CITY OF ALBUQUERQUE

RE: **Worthan Residence**
7908 Shiprock Ct. NW
Lot 21 Block 7 Volcano Cliffs Sub. SAD 227
Grading and Drainage Plan
Engineers Stamp Date 4/20/18 (E10D046)

Based upon the information provided in your submittal received 4/30/2018, the above referenced Grading and Drainage Plan cannot be approved for Grading Permit until the following comments are addressed.

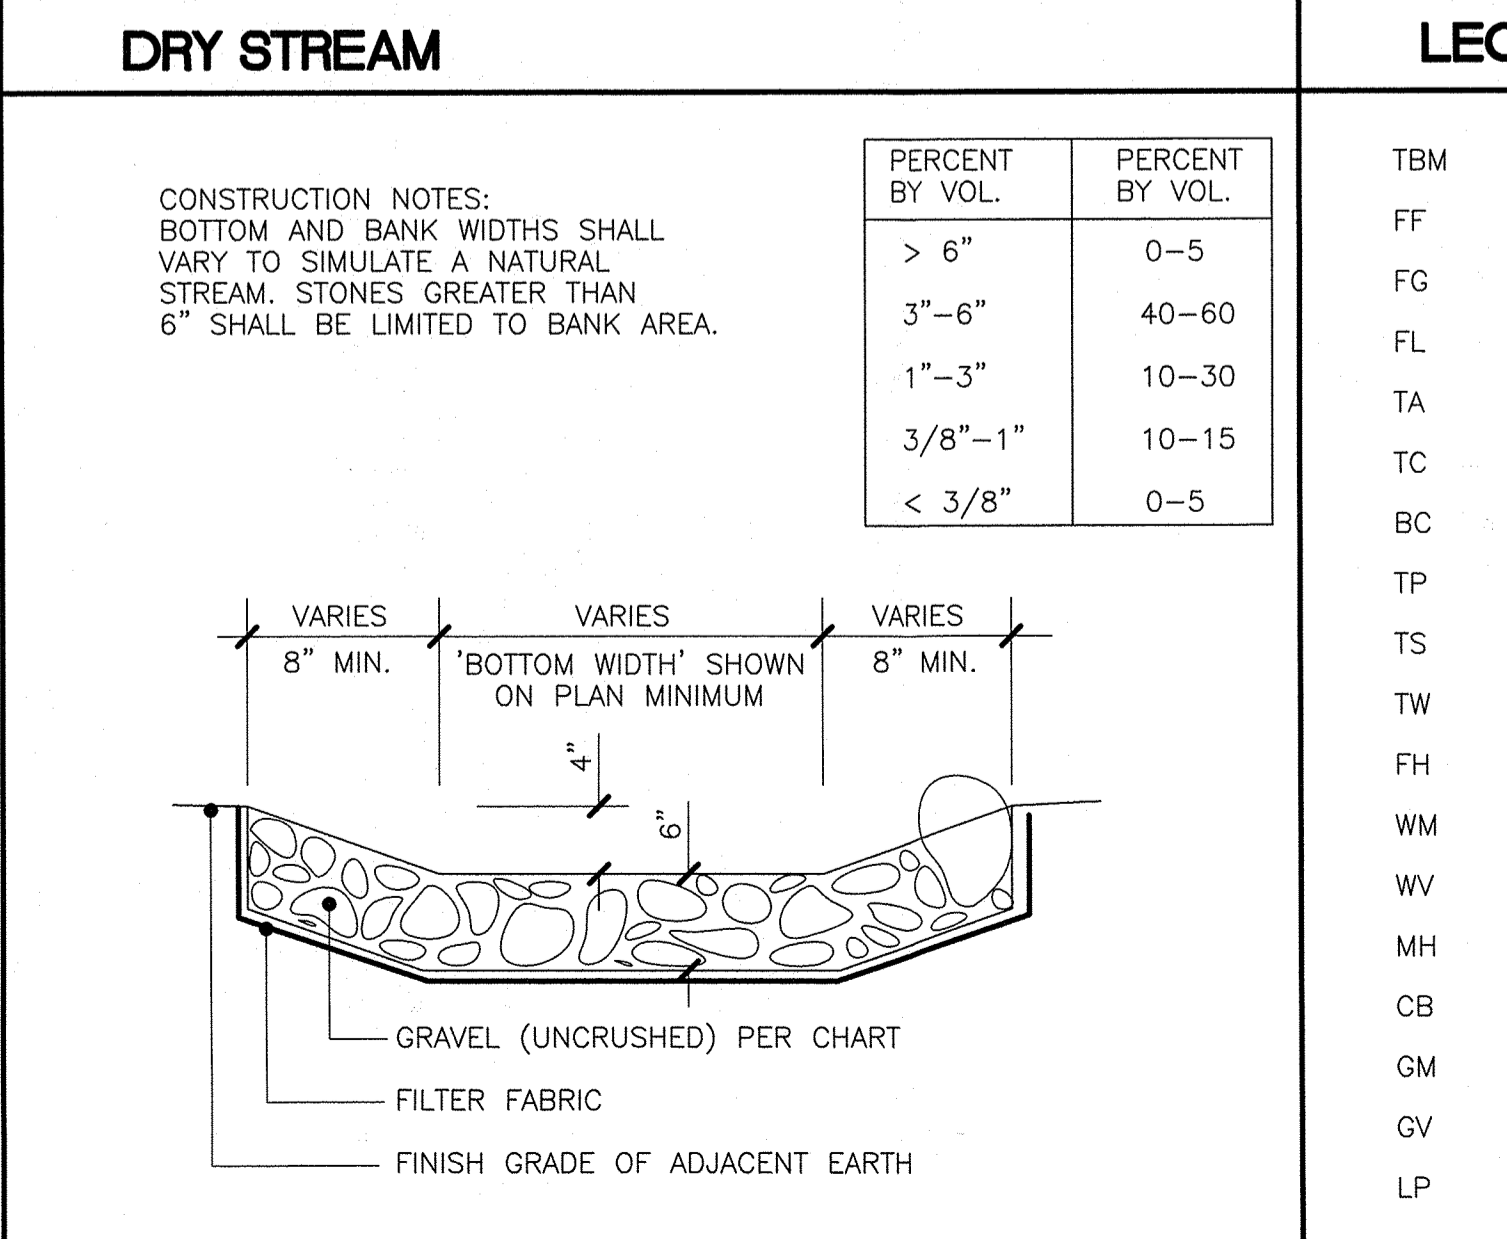
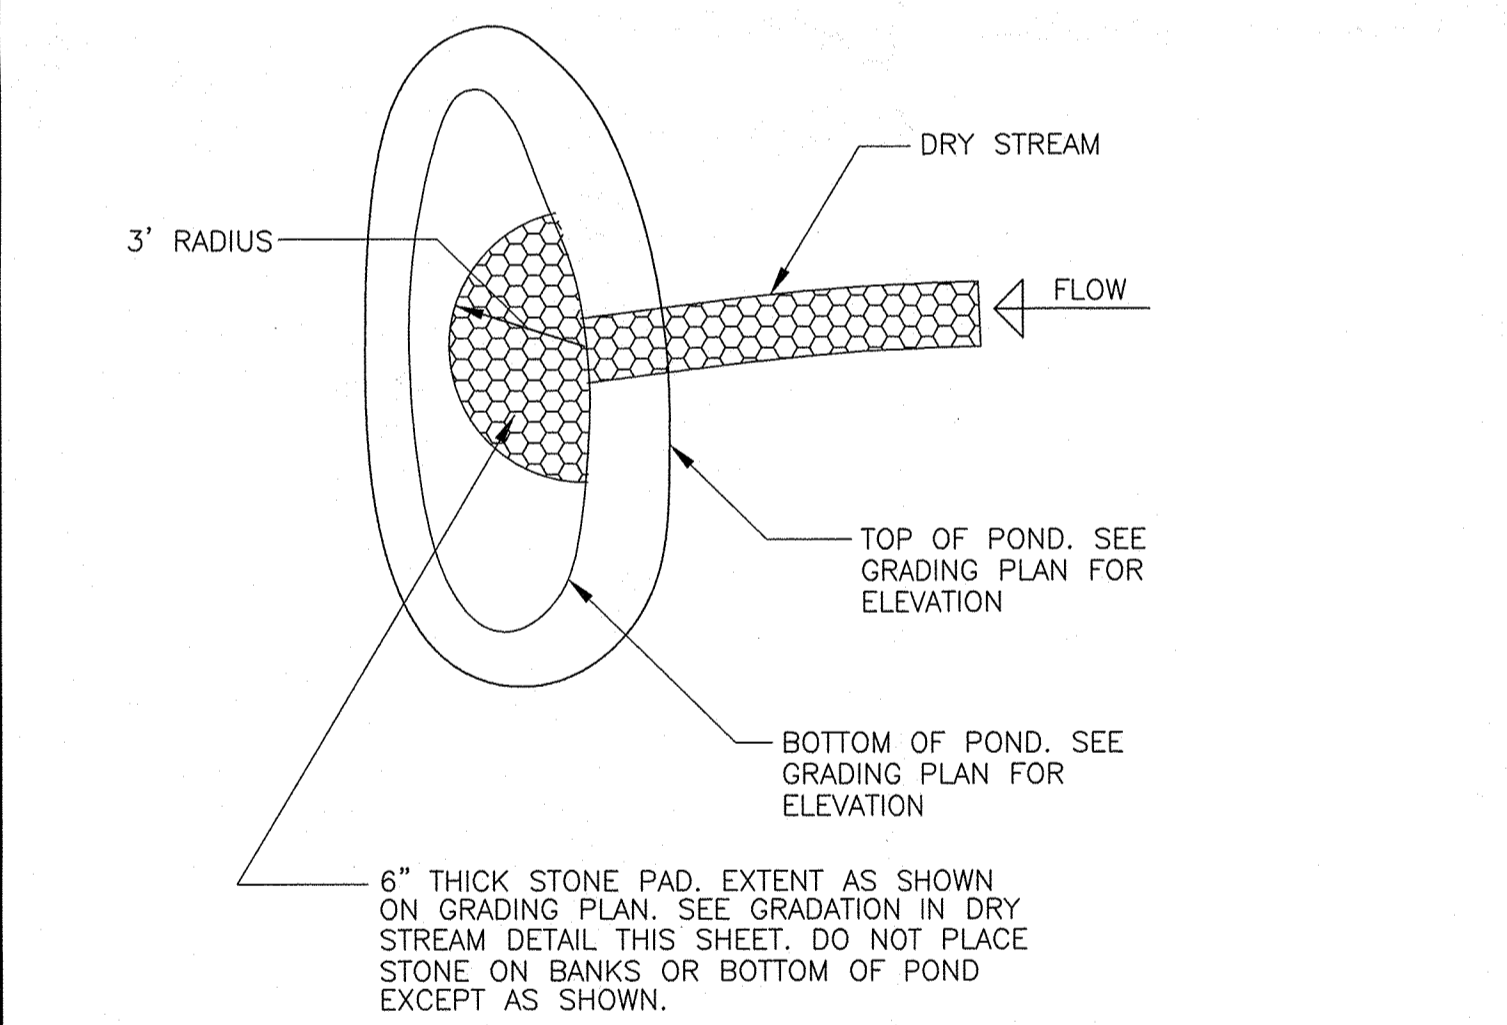
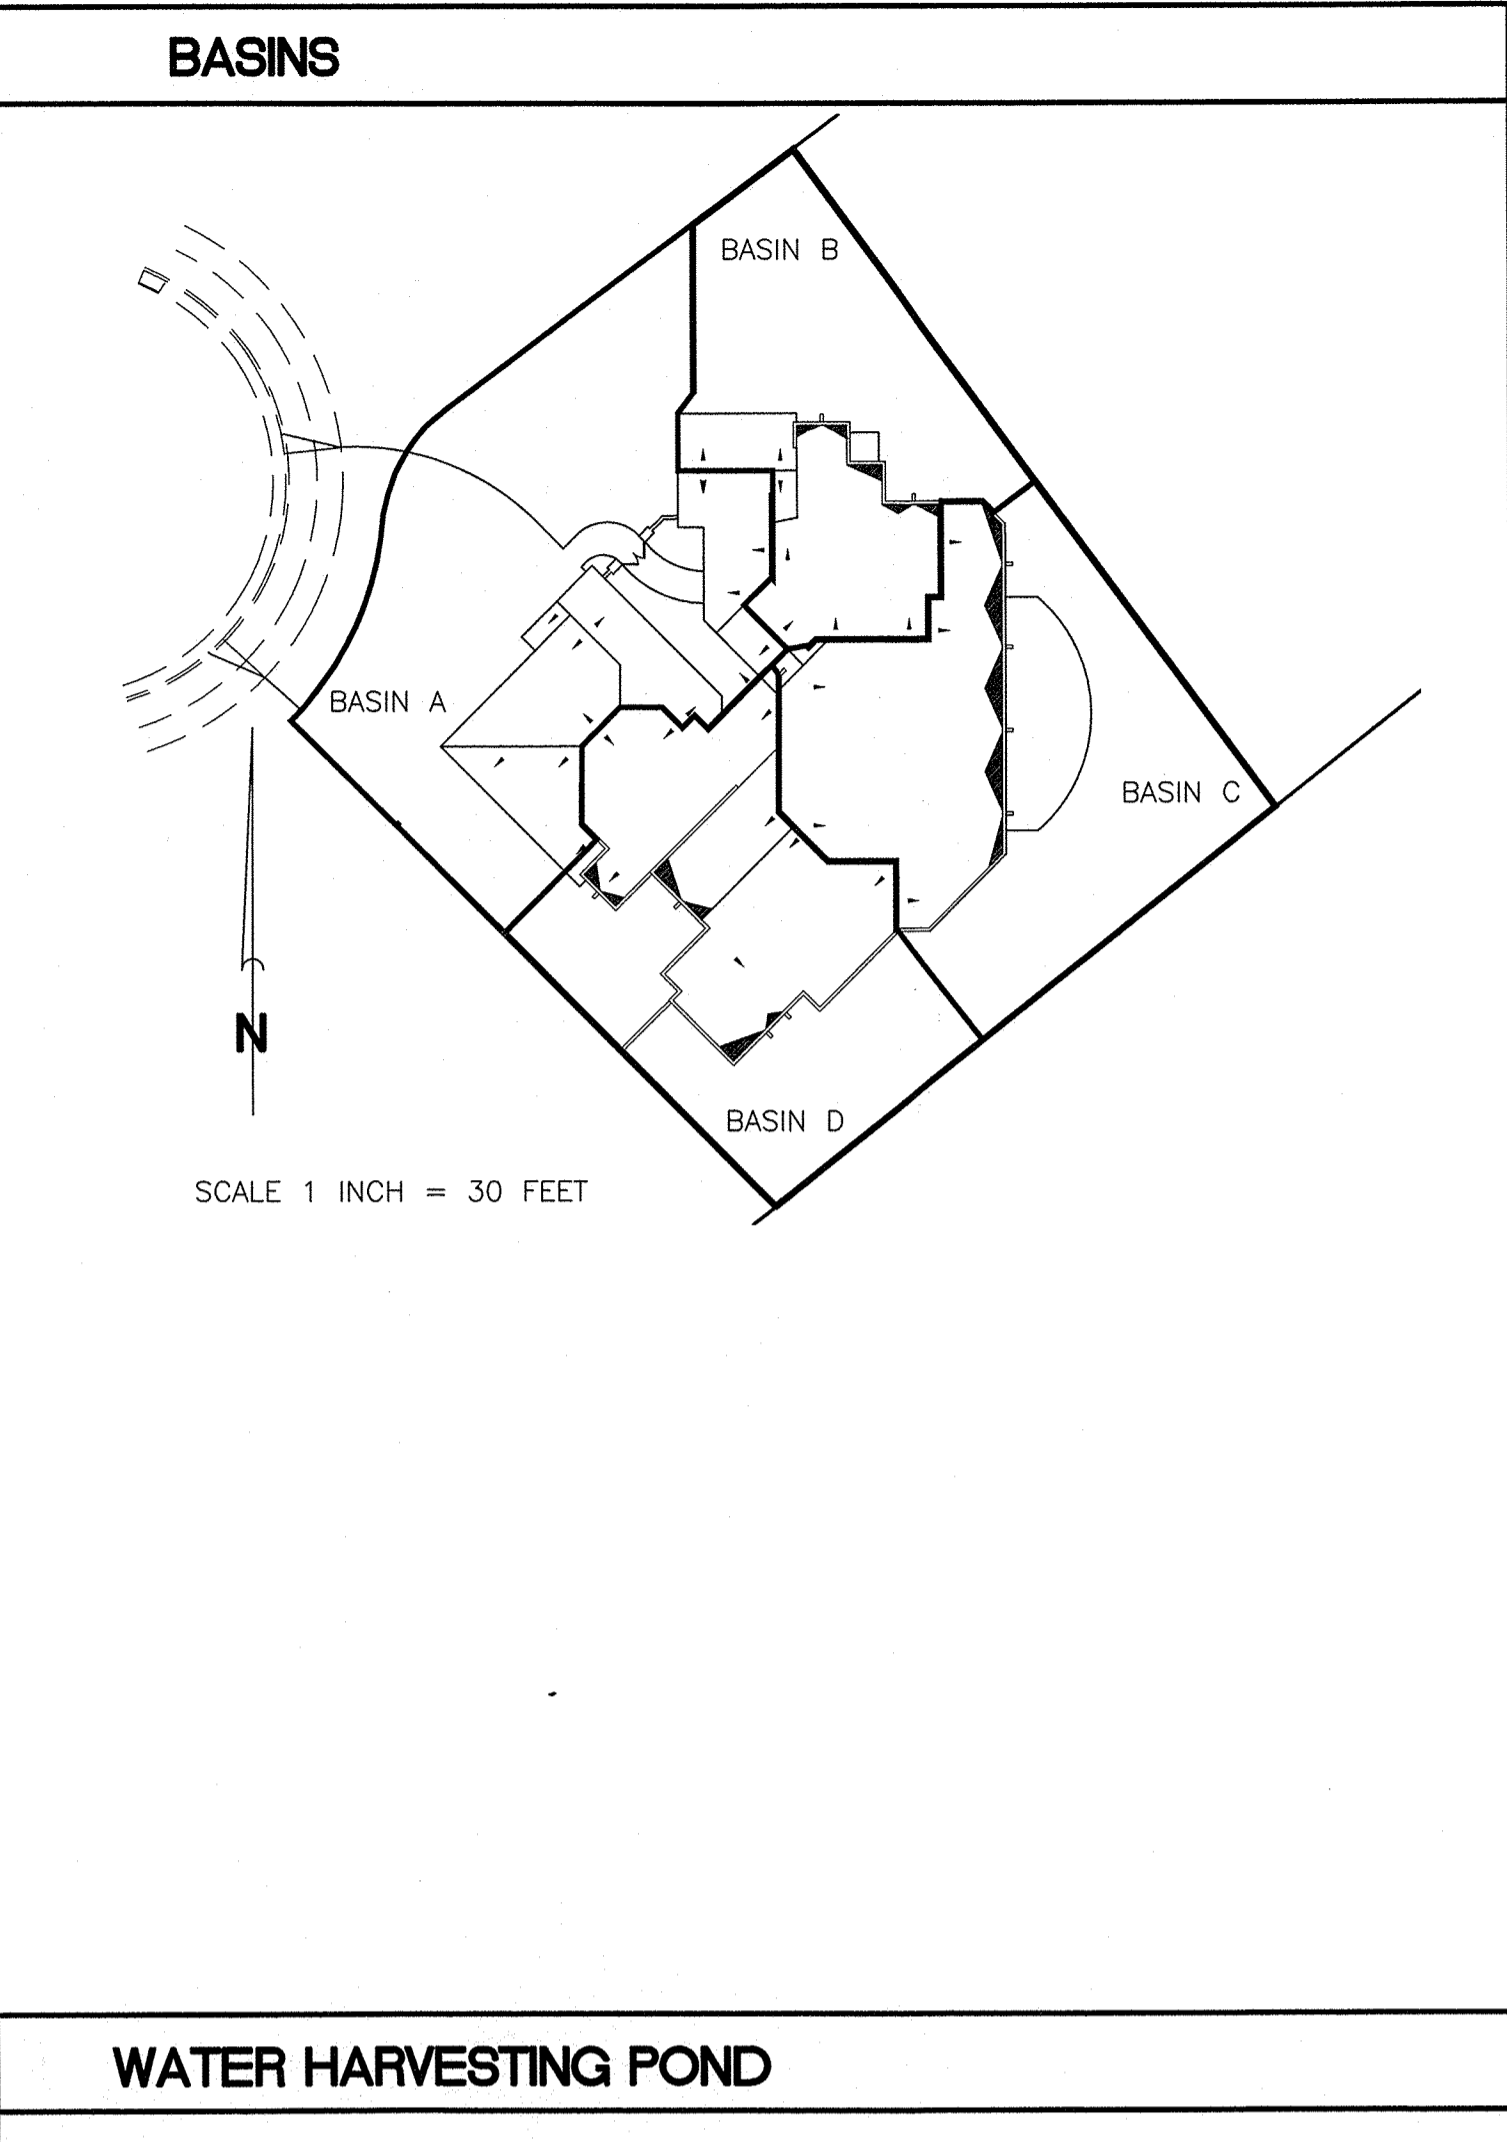
- Provide openings in the block fence 3" above grade.
- Remove rip rap outside of property line or provide a letter or Email from Open Space giving permission for the rip rap and flows to enter into their national park.
- Provide a cross section of the block wall showing the lot line and the footing line. If the footing is encroaching into abutting properties provide an encroachment agreement or place the entire footing on the inside of the property line.
- Provide a note stating that a permit is required for all garden walls or fencing and this is the plan to be used for the permit.
